Our Ref: Y/69/18/HH

**Town & Country Planning Act 1990 (as amended)
Town & country Planning (Development Management Procedure) (England) Order 2015
Application for Planning Permission for Works or Extension to a Dwelling**

Development Driveway to front of property & new vehicular access.

Location 8 East Bank North End Road Yapton

site plan

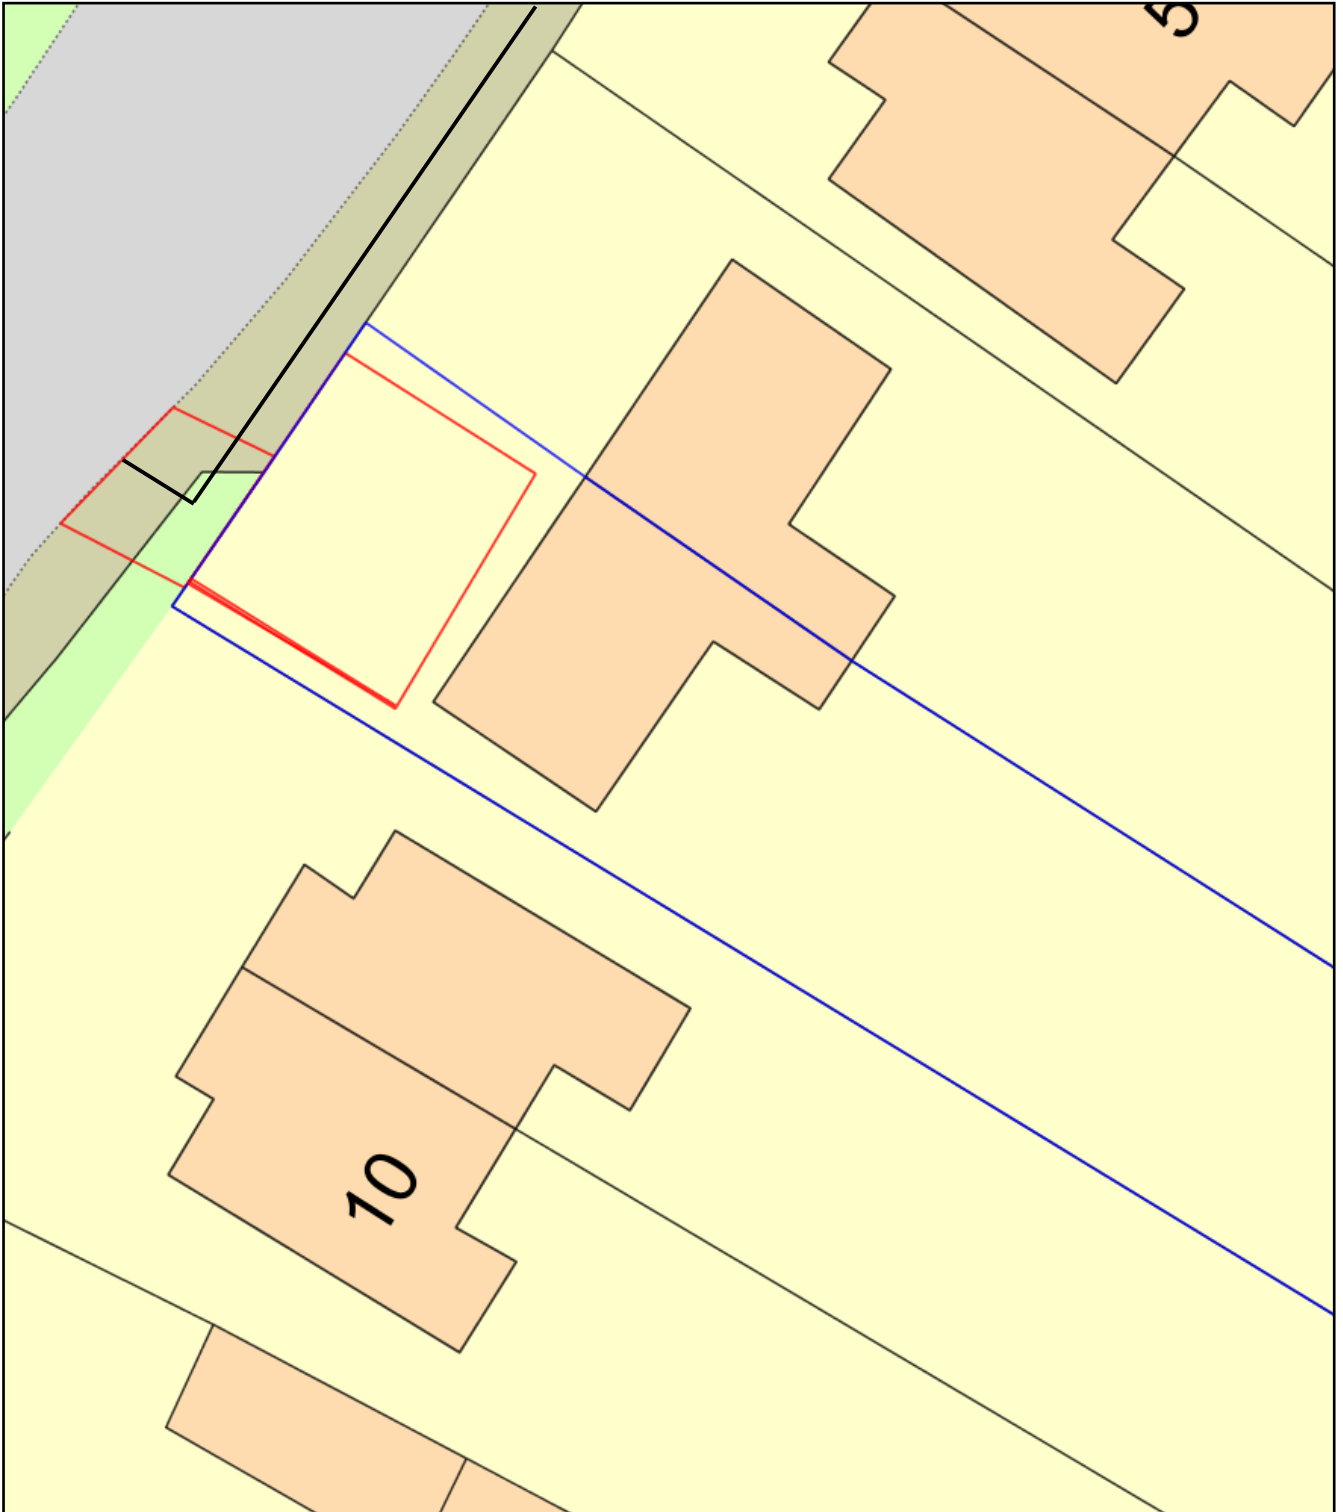
Block Plan Amend

Please provide visibility splays.

Please provide details of the proposed materials for the new driveway.
